# CONSTRUCTION PLANS FOR HILLSIDE AT LORSON RANCH FILING NO. 1 STREET & STORM SEWER CONSTRUCTION PLANS

**HILLSIDE AT LORSON RANCH FILING NO. 1  
STREET & STORM SEWER  
CONSTRUCTION PLANS**

DATE:  
DEC 1, 2022  
PROJECT NO.  
100.065  
SHEET NUMBER  
**C1.1**  
TOTAL SHEETS: 47

Signing and Striping Notes:

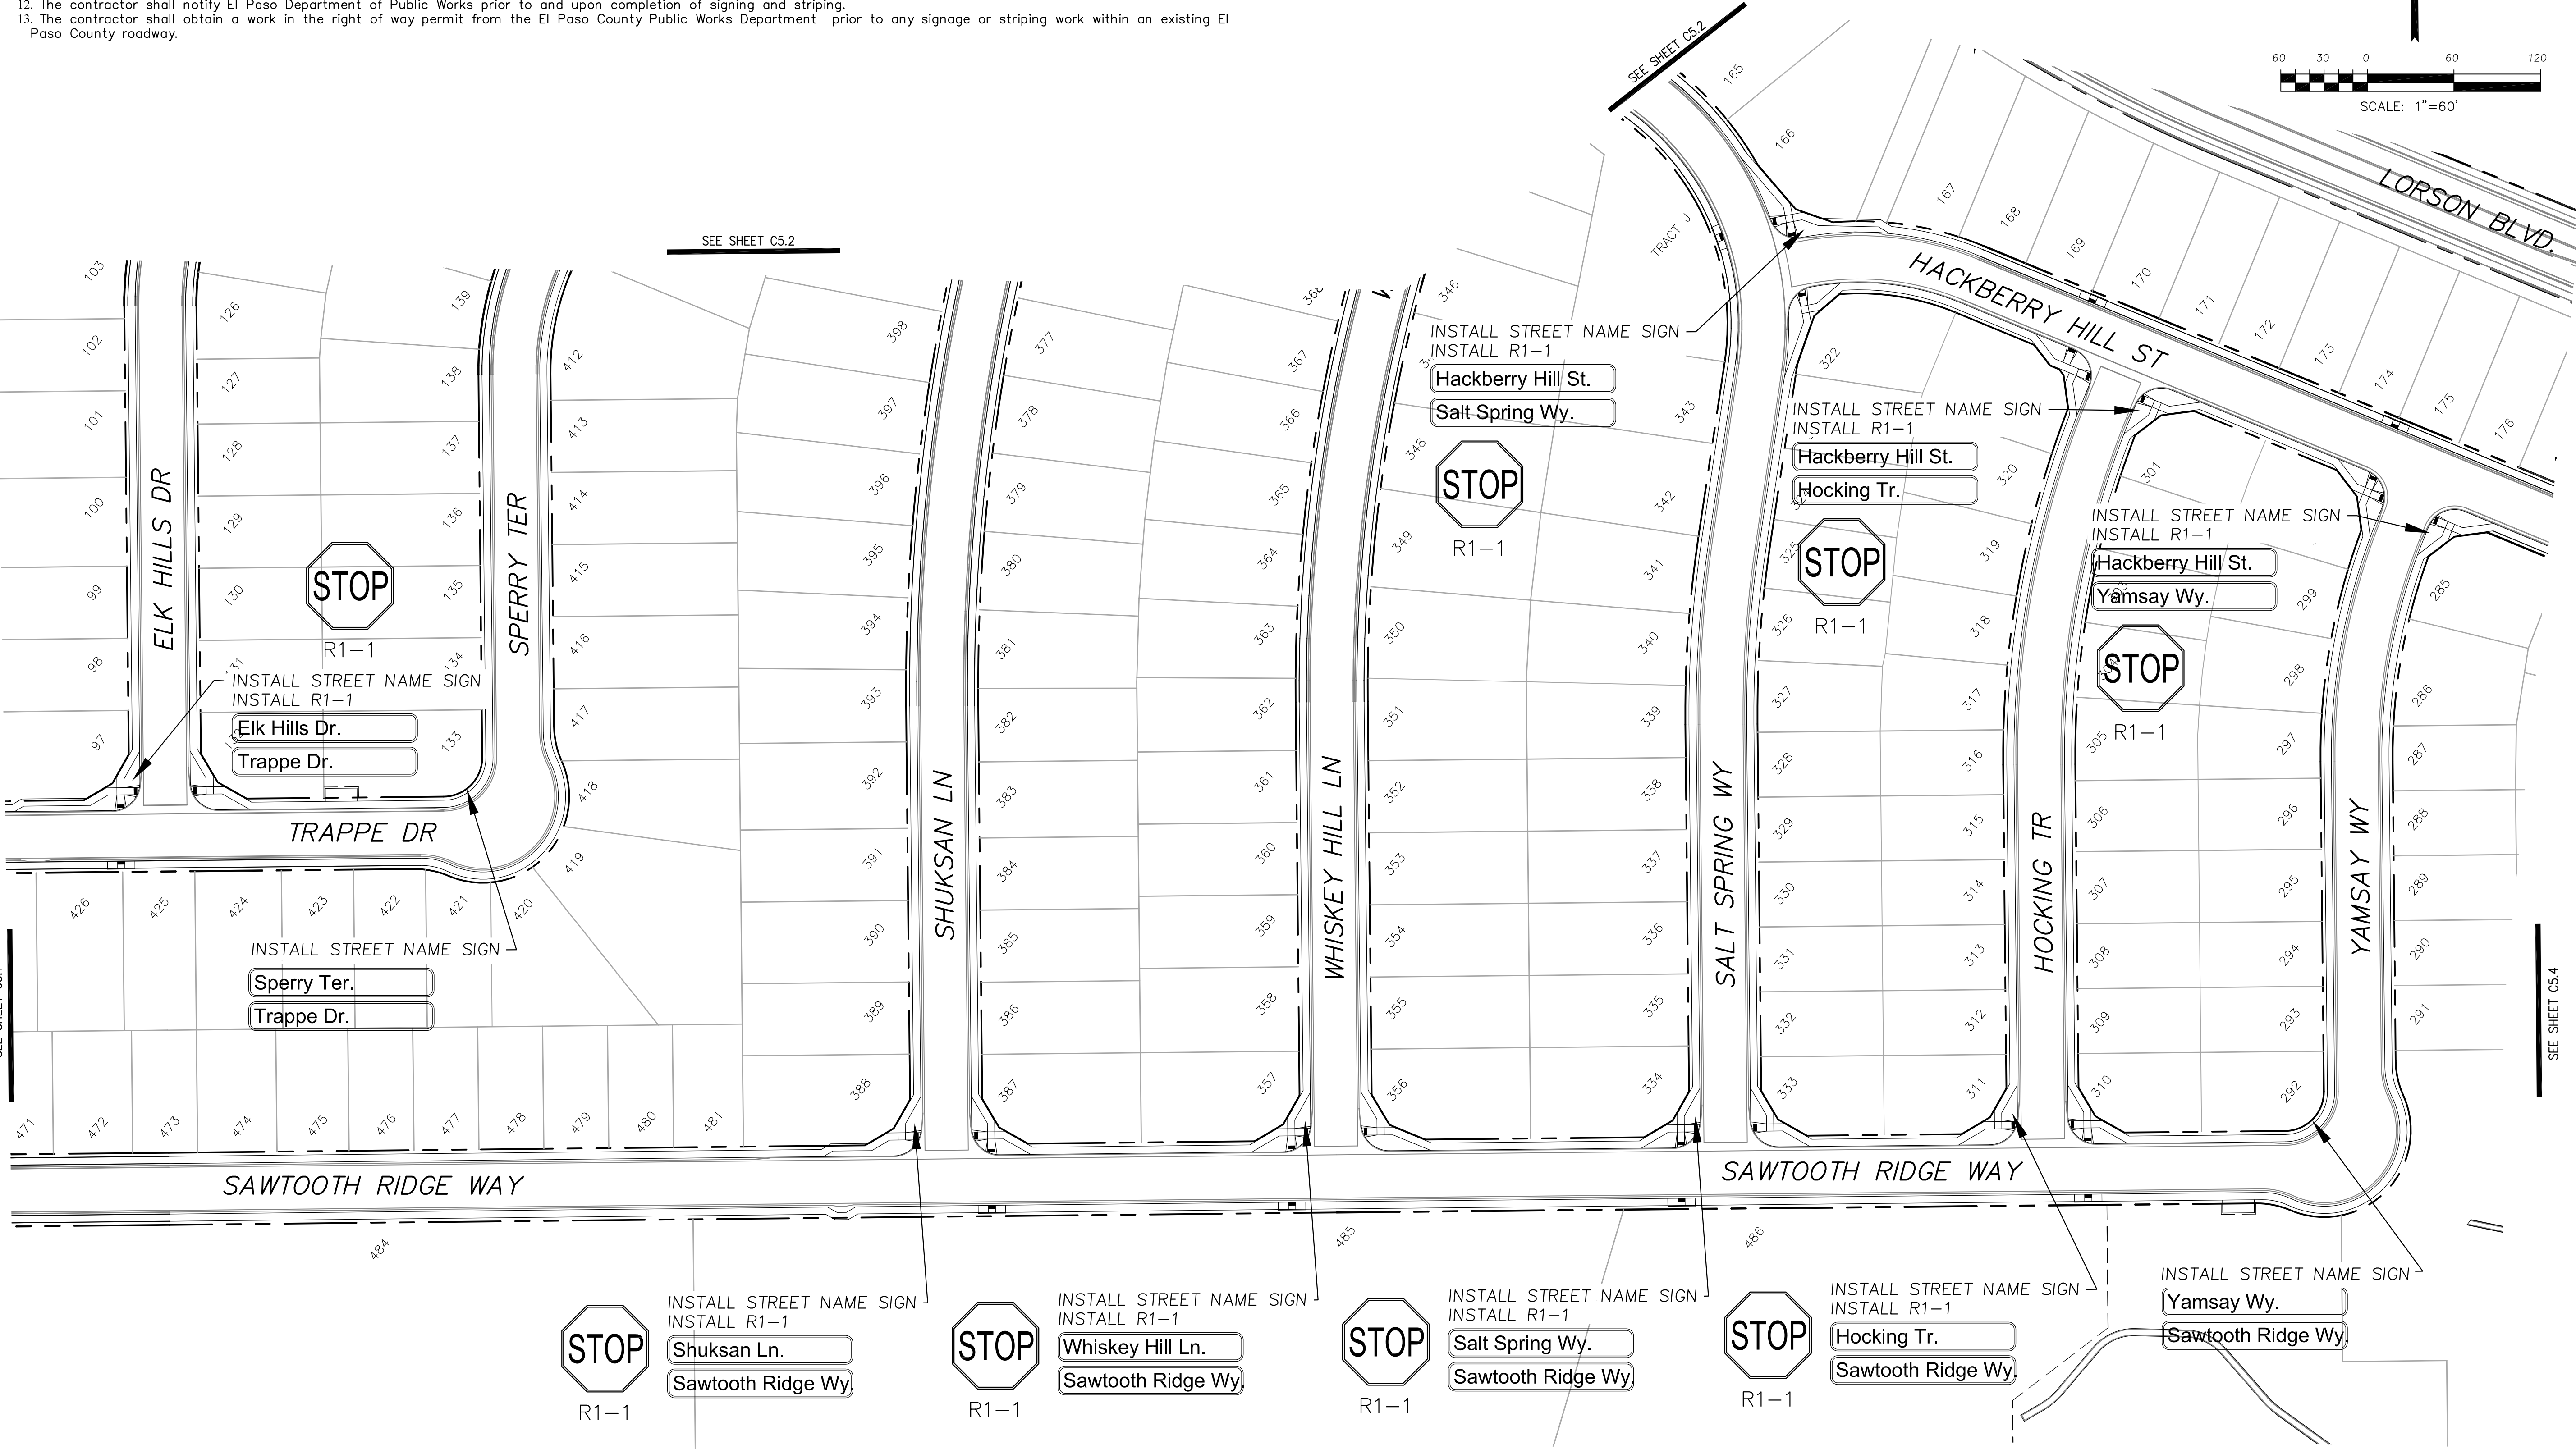
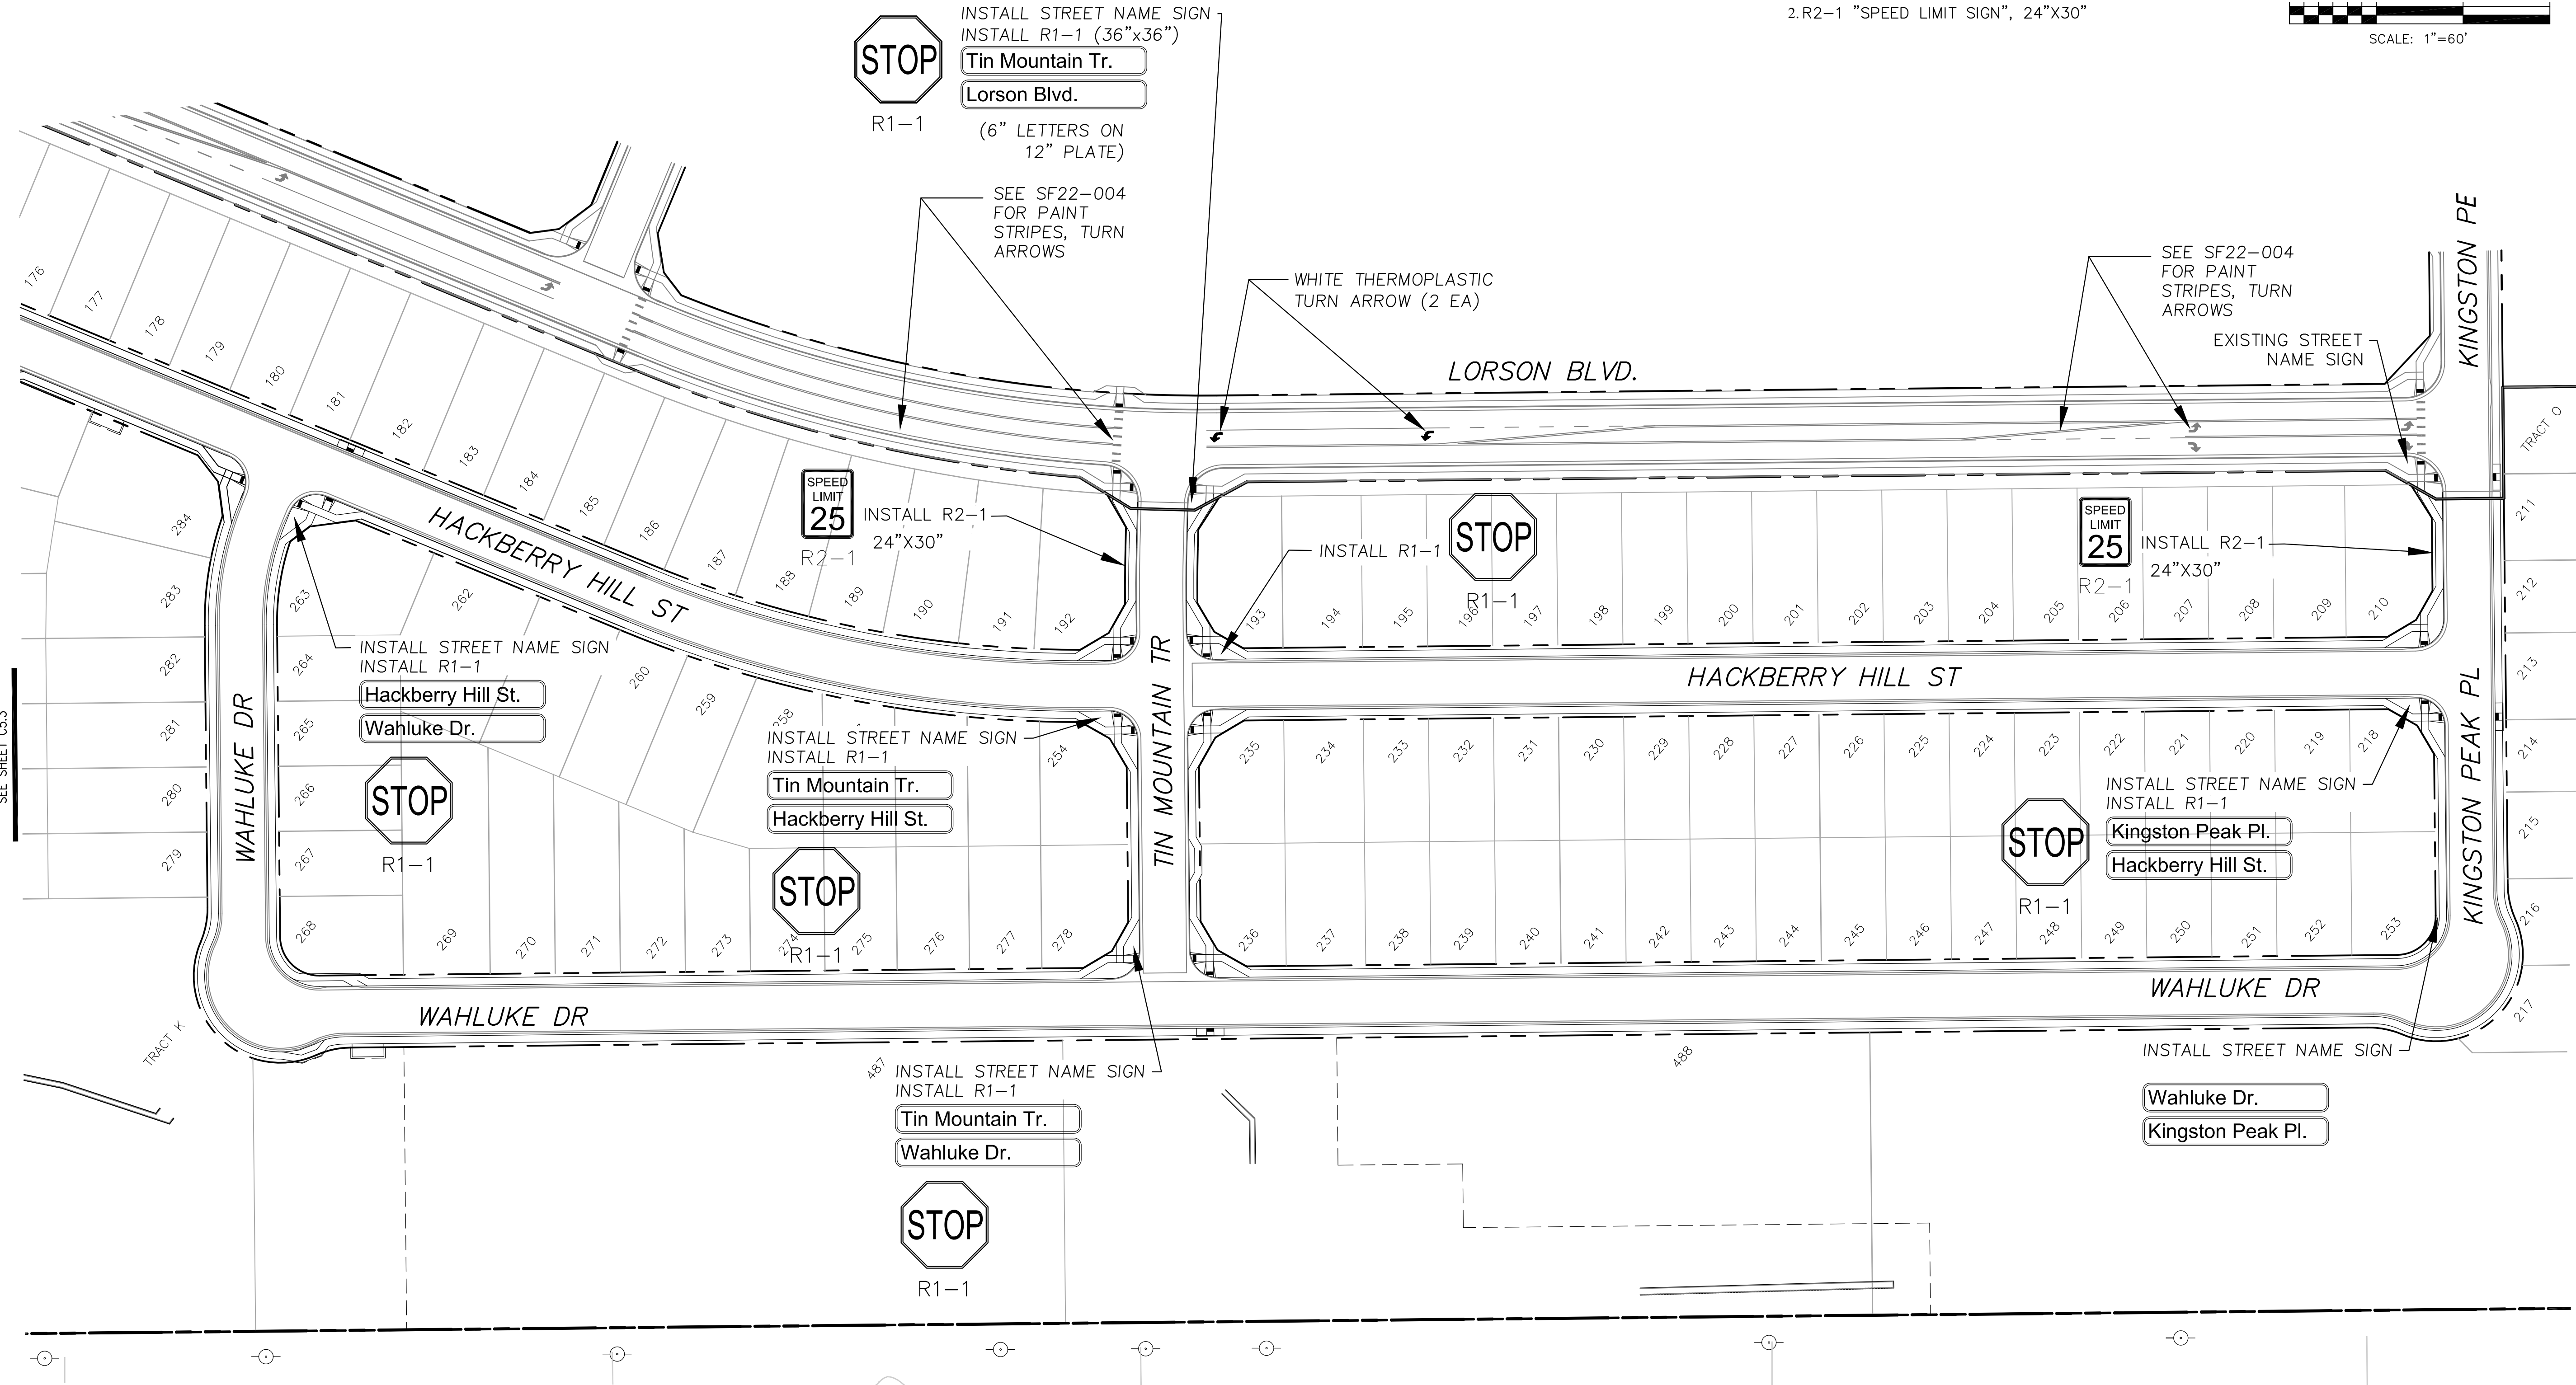
Change "Planning and Community Development" as highlighted in notes, to "Department of Public Works"

TYPICAL SECTIONS

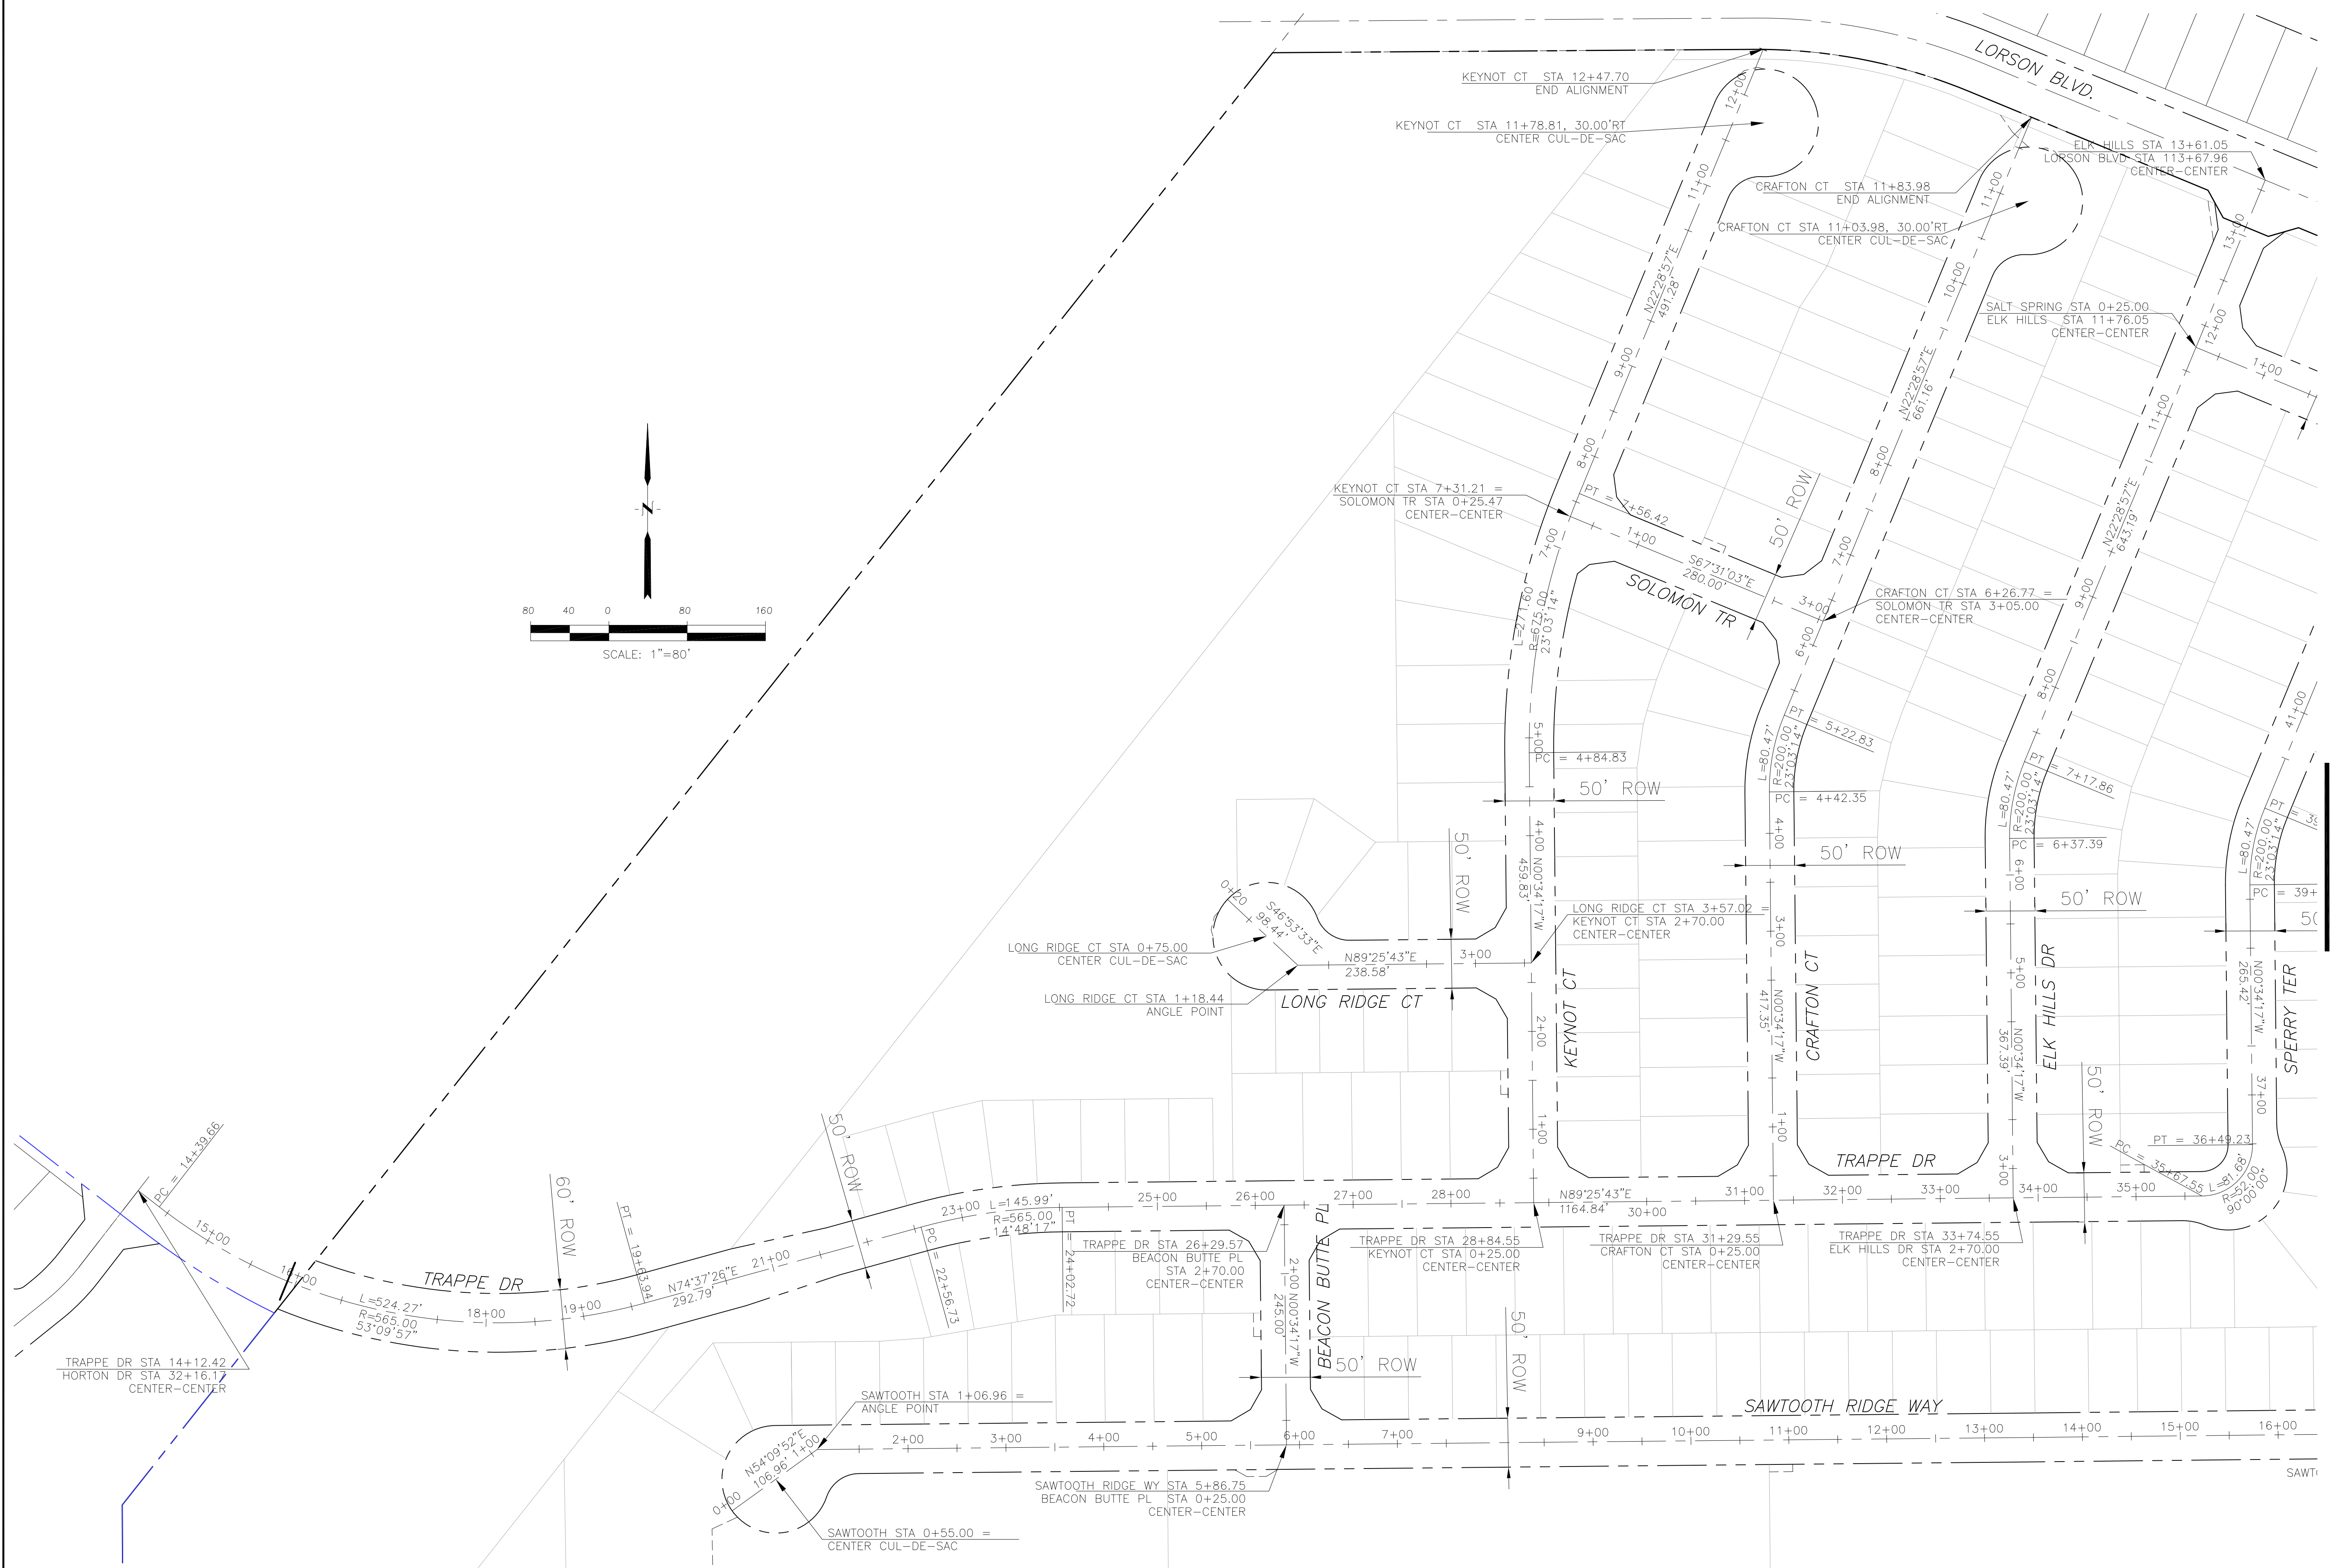
Delete  
Sidewalk along these roads may be 4" except at driveways

NOTE:  
Pavement section to be determined  
by Hveem analysis and design. Design  
to be approved by El Paso County PCD Engineering

NOTE:  
Pavement section to be determined  
by Hveem analysis and design. Design  
to be approved by PCD Engineering
